From: Bill Sheaves <sheavesw@gmail.com>
Sent: Tuesday, April 13, 2021 1:45 PM
To: Nina Ruiz <NinaRuiz@elpasoco.com>
Cc: Bill Sheaves <sheavesw@gmail.com>
Subject: Independence Place at Cheyenne Mountain Fil No. 1A

Subject: Independence Place at Cheyenne Mountain Fil No. 1A

File VR214
Parcel ID No. 643330149

INDEPENDENCE PLACE AT CHEYENNE MOUNTAIN FILING NO. 1A

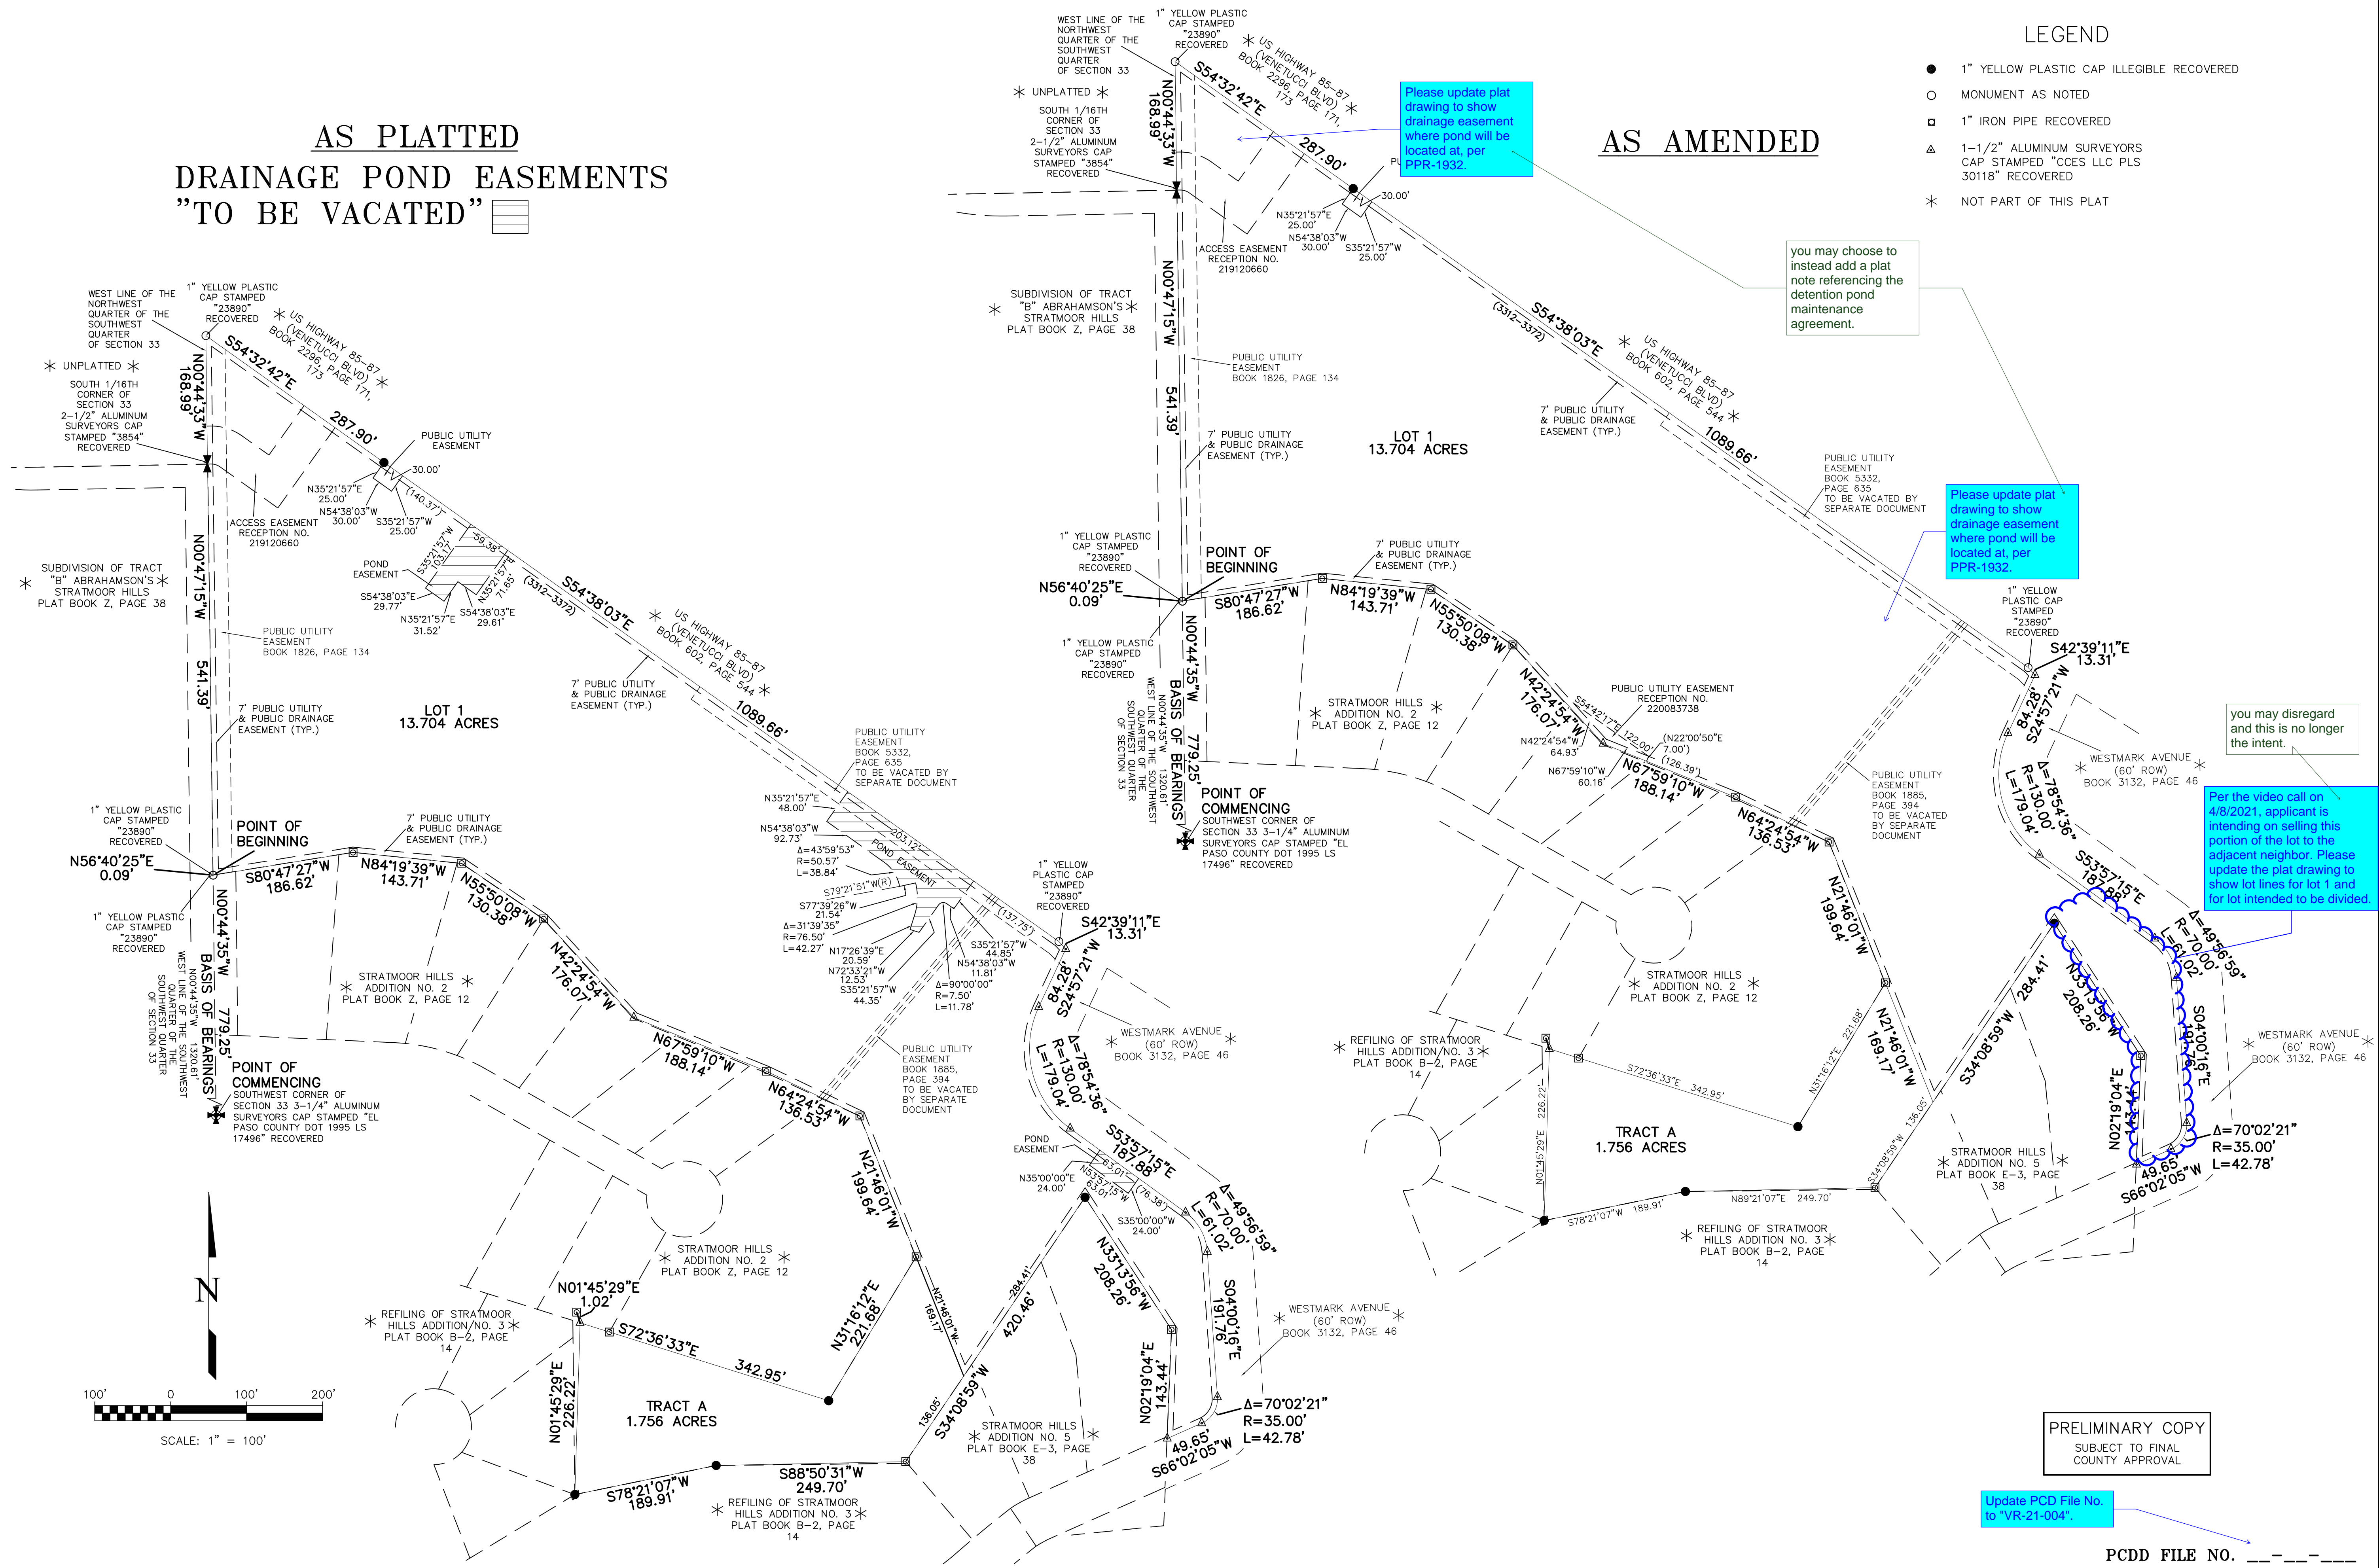
My understanding is the applicant is seeking to change the location of the required retention ponds on the development property. While I can see where the approved retention ponds were to be located on the current plat map, the application does not reveal exactly where the retention ponds will be relocated to. This absence of information causes us concern. Without this knowledge, we have no way to determine if the relocated retention ponds and drainage will impact our church property, either directly or indirectly. Therefore, we cannot agree to the application in its current form, and we reserve the right to review and, if necessary, object to the relocation, once this information is provided to us.
